A/121/15/PL – HERONS FARM, DAPPERS LANE, ANGMERING

As the owners and occupiers of the adjoining property, we should like to register the following objections and concerns regarding the above Planning Application A/121/15/PL for the demolition of existing structures and the construction of two cottages, stabling and a sand school. We have made our neighbours aware of these concerns.

Drg No. 459/03	Rev.
-------------------	------

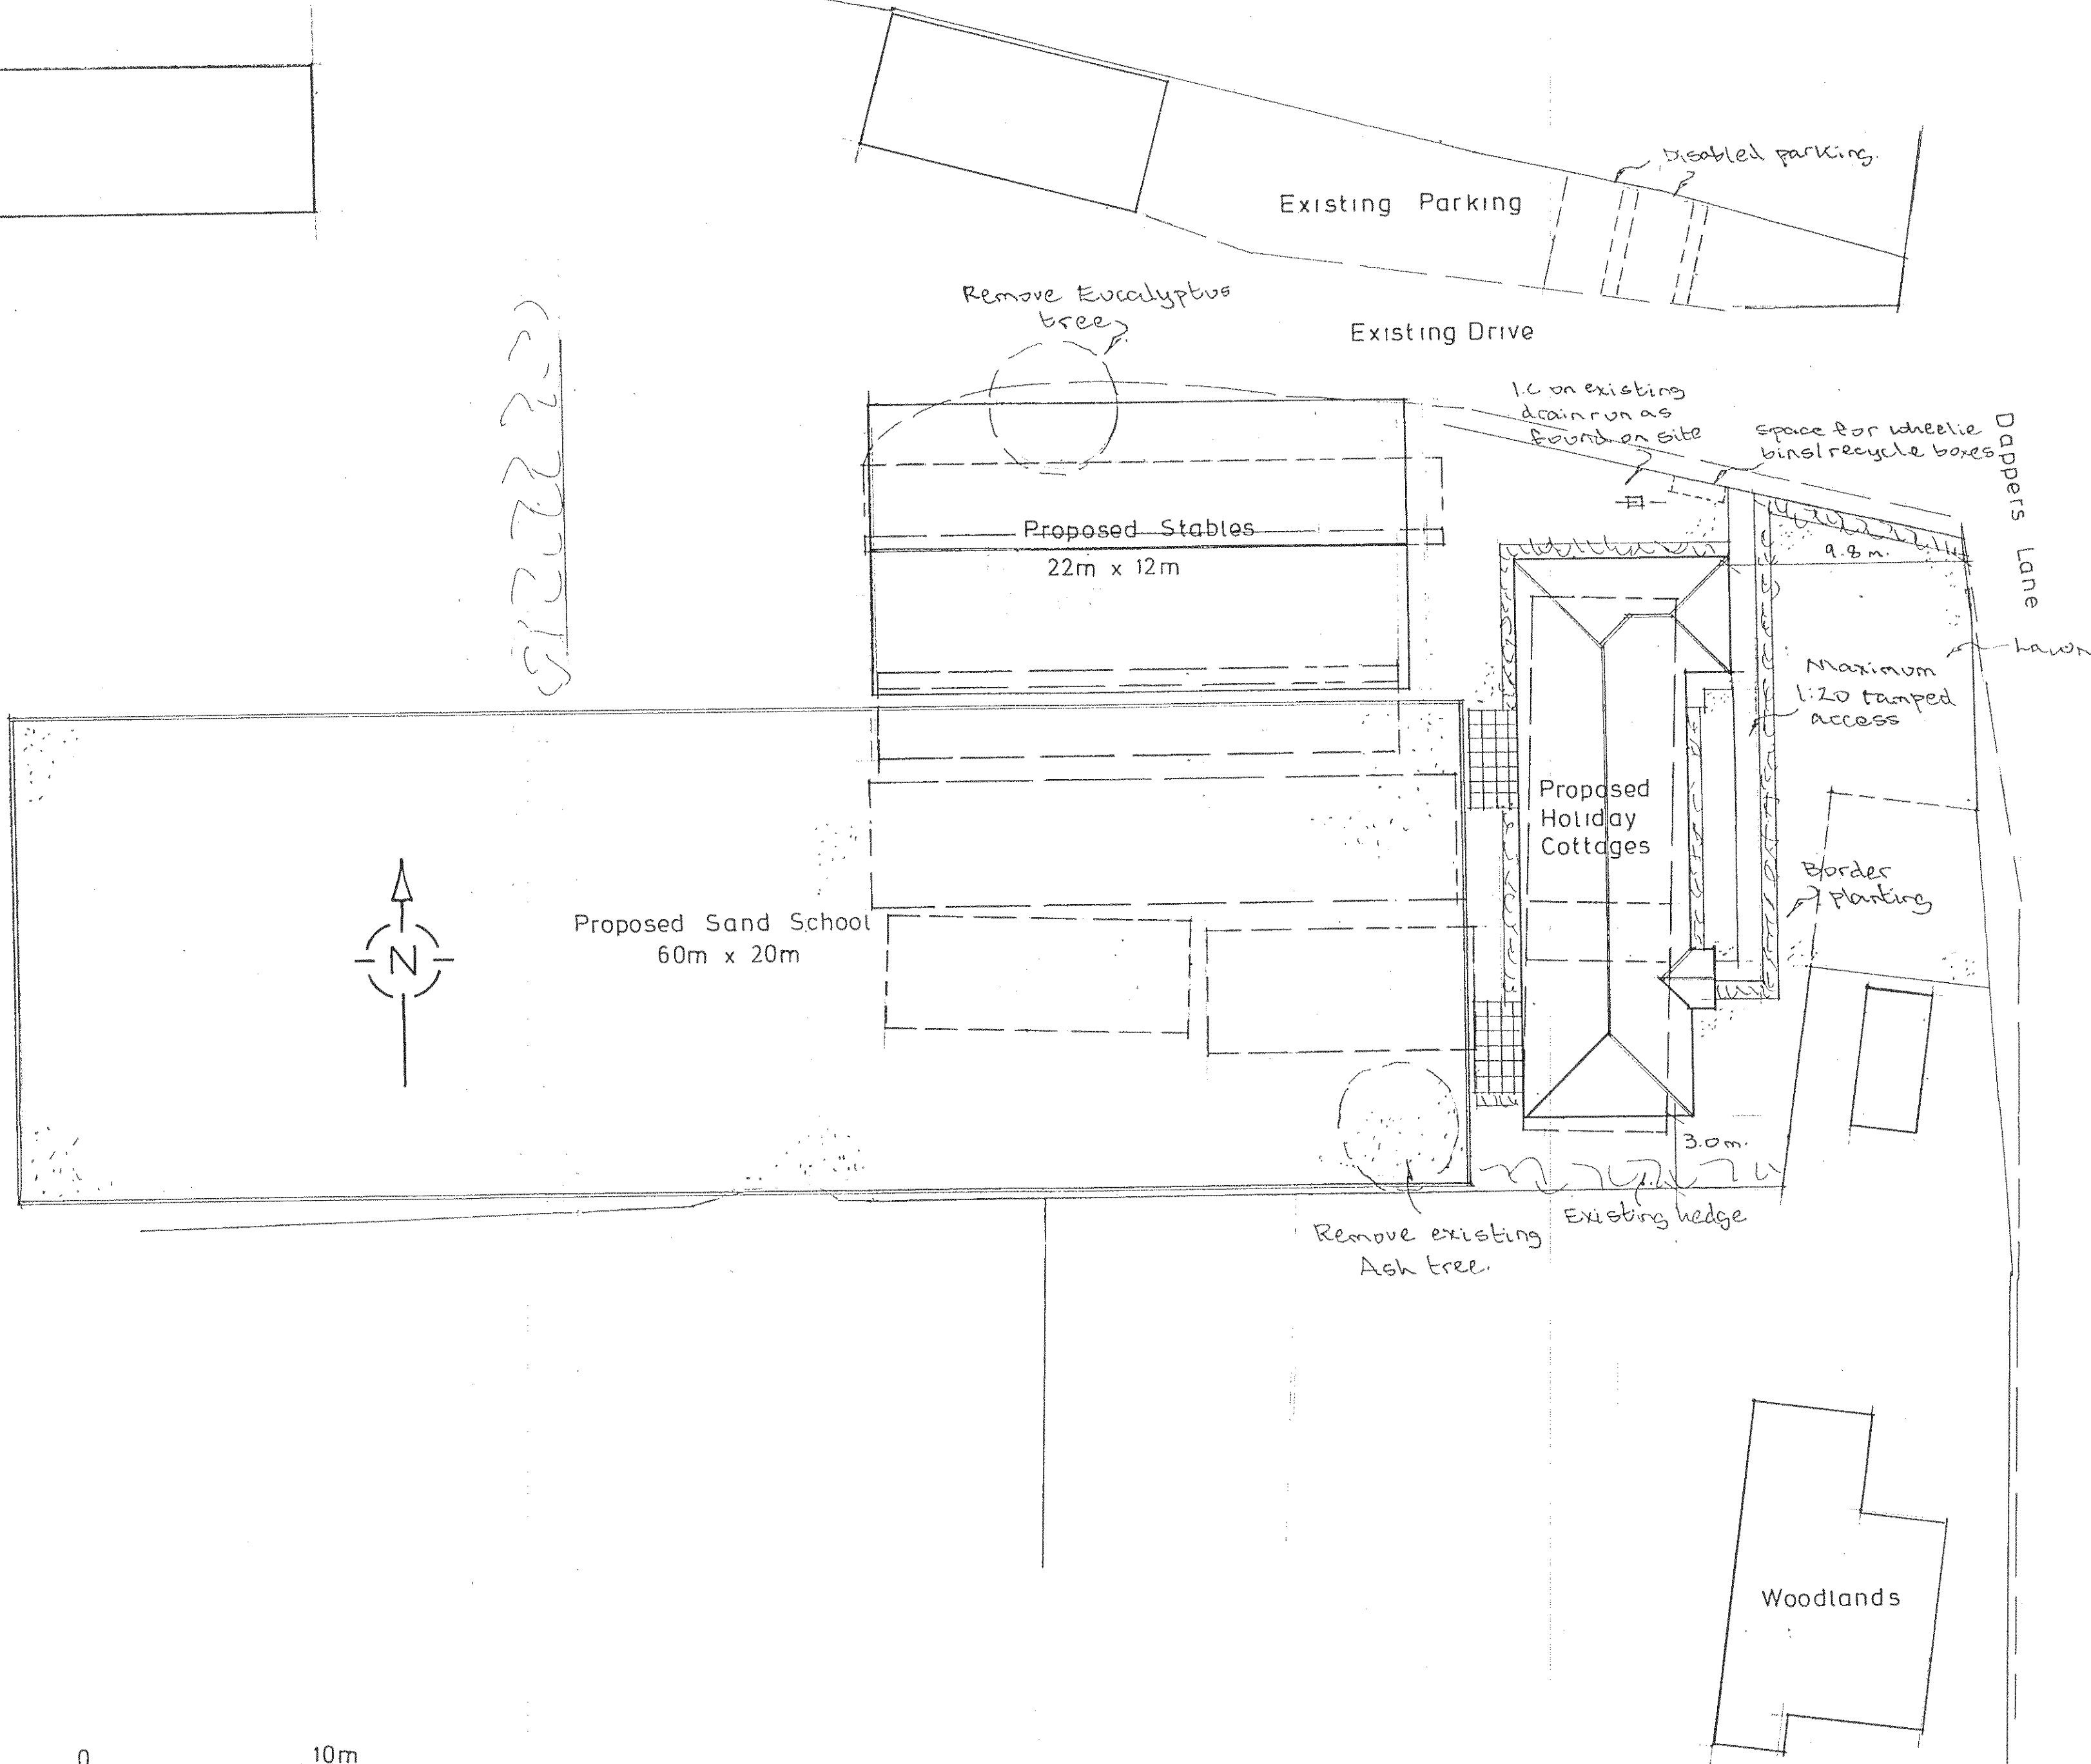
In respect of the boundary to the south and east of the proposed cottages, the plan shows "existing hedges". There is no existing hedge – the boundary is defined by fencing, currently in a poor state of repair and thickly covered by ivy and other vegetation. During our discussions with our neighbours (the applicant) they have indicated a willingness, through a combination of replacement fencing and lowering the foundation level of the cottages, to prevent our property from being overlooked. Whilst we appreciate this, in order to completely preserve our privacy it would result in the height of a fence or wall being very overpowering and intrusive in itself, and would be totally out of keeping with the rest of our garden and, indeed, the rural nature of this area. Additionally, it would not address the issue of noise disturbance from, potentially, a continuous stream of different people (including children) enjoying short stay holidays.

Proposed Block Plan

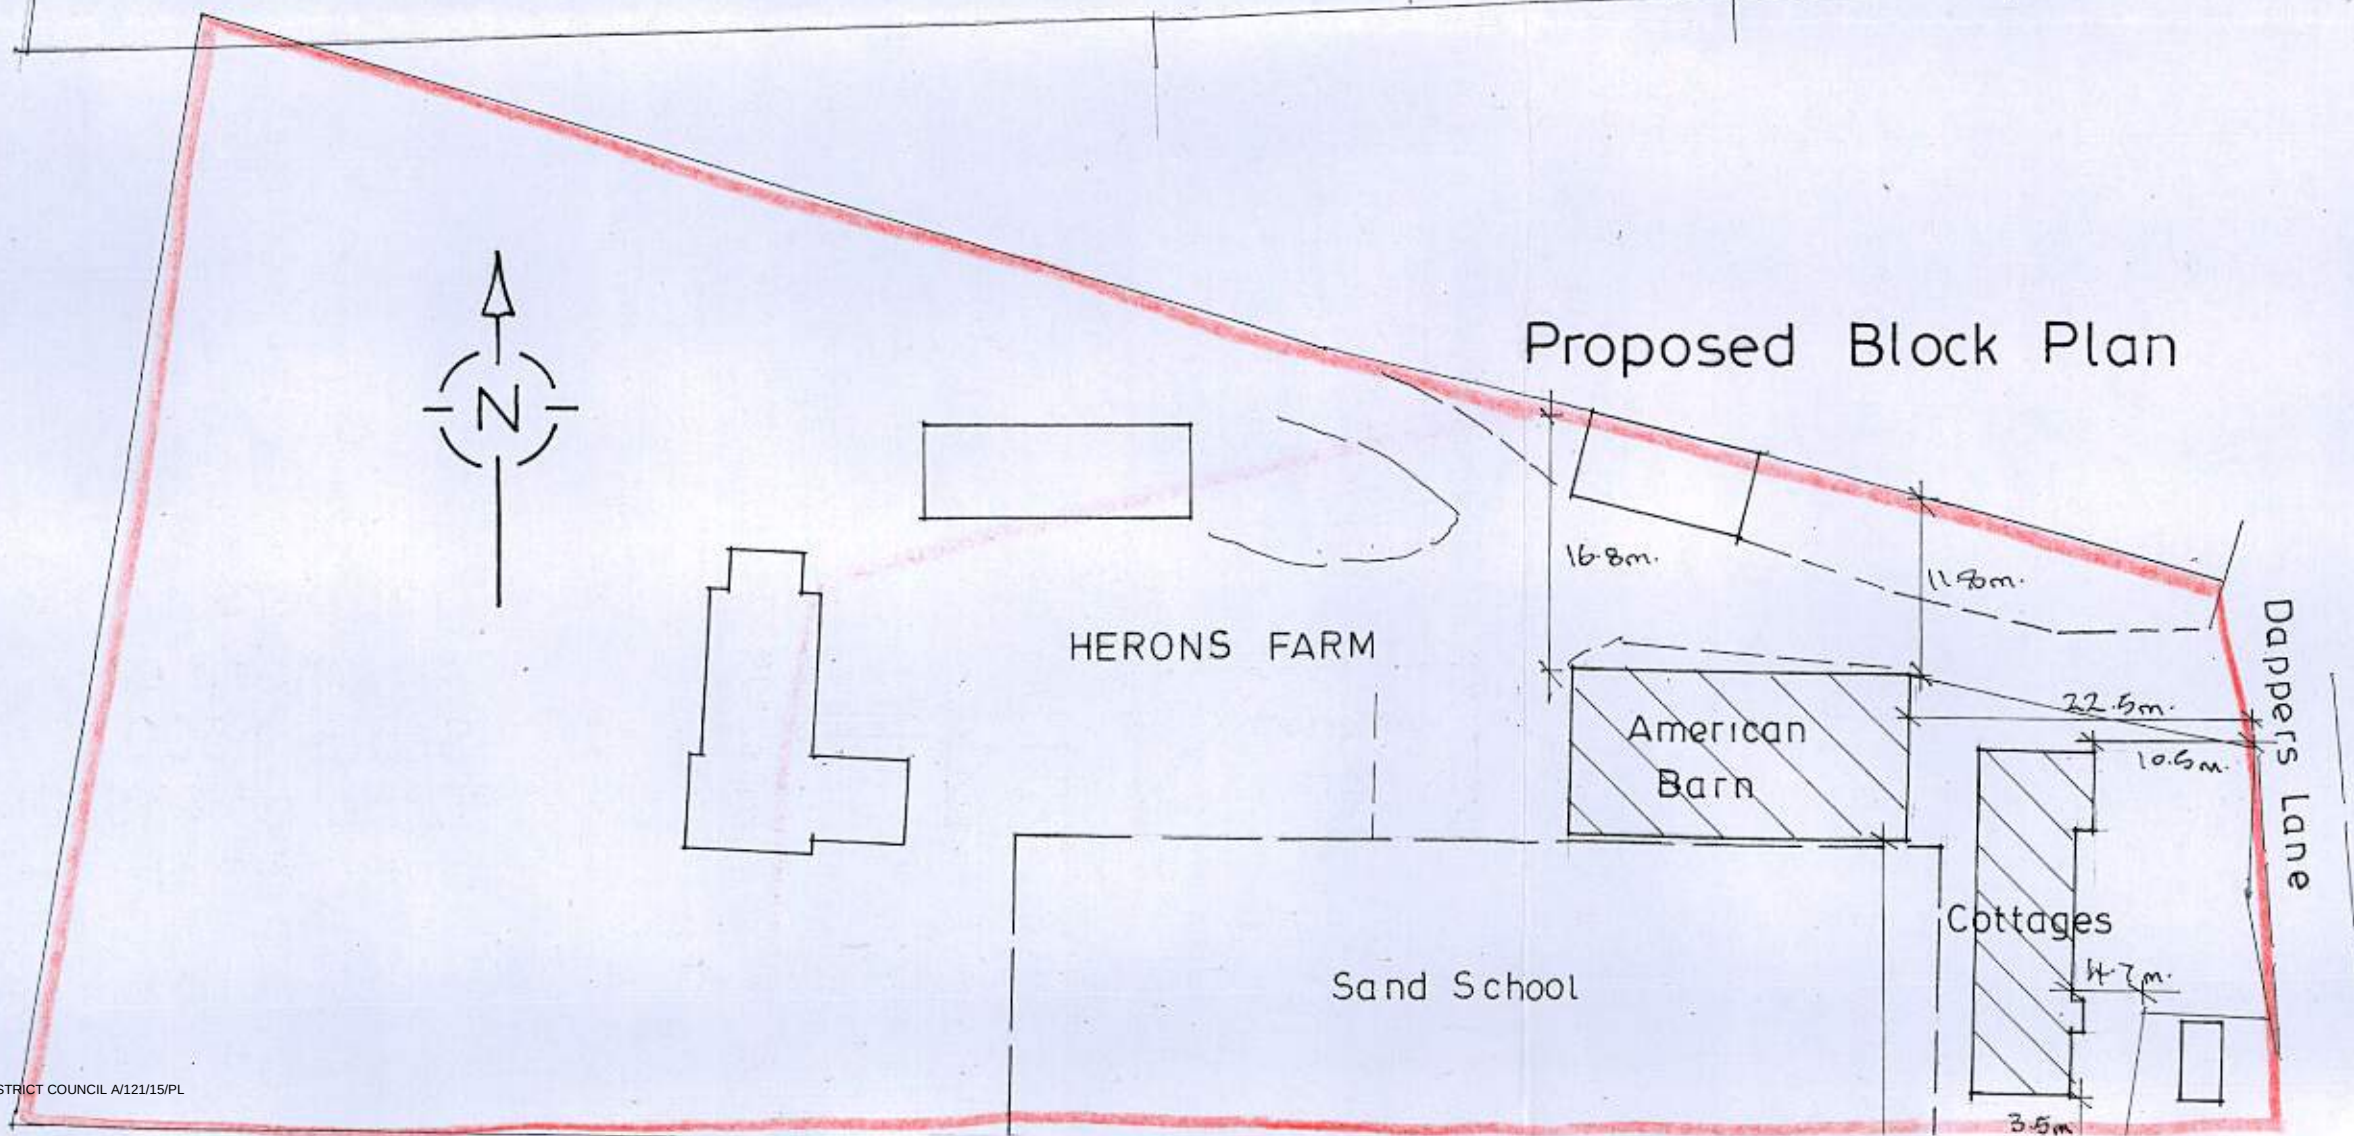
The application is to build the two cottages just 3.5 metres from the northern boundary of our home and garden in a position which is at the nearest point to our house. Although of single storey construction, the fact that the cottages would be built on land which is significantly elevated will mean that our property will be overlooked from the windows on the West, East and the South sides. This, together with the inevitability of noise generated by holiday occupiers of the cottages (potentially throughout the year) and from the sand school, would result in loss of our privacy and disrupt the peace and tranquillity of our home and garden. We understand there is also an intention to create a garden for each of the properties. The north cottage garden would be in front of that building and the one for the south cottage would be situated between that building and our boundary thereby further increasing the level of disturbance.

Heron's Farm is situated within a large parcel of land, giving scope for the cottages to be constructed much further to the West. The proposed development is sited at the furthest point to the East from the applicants' property but at the closest point to our own, thereby enabling them to protect their own privacy at the expense and to the detriment of the privacy and quiet currently enjoyed by us. Moving the location of the cottages to the West would also mean that they would be sited further from Dappers Lane and, contrary to what is stated on the application form, the currently proposed location will render them visible from the public highway.
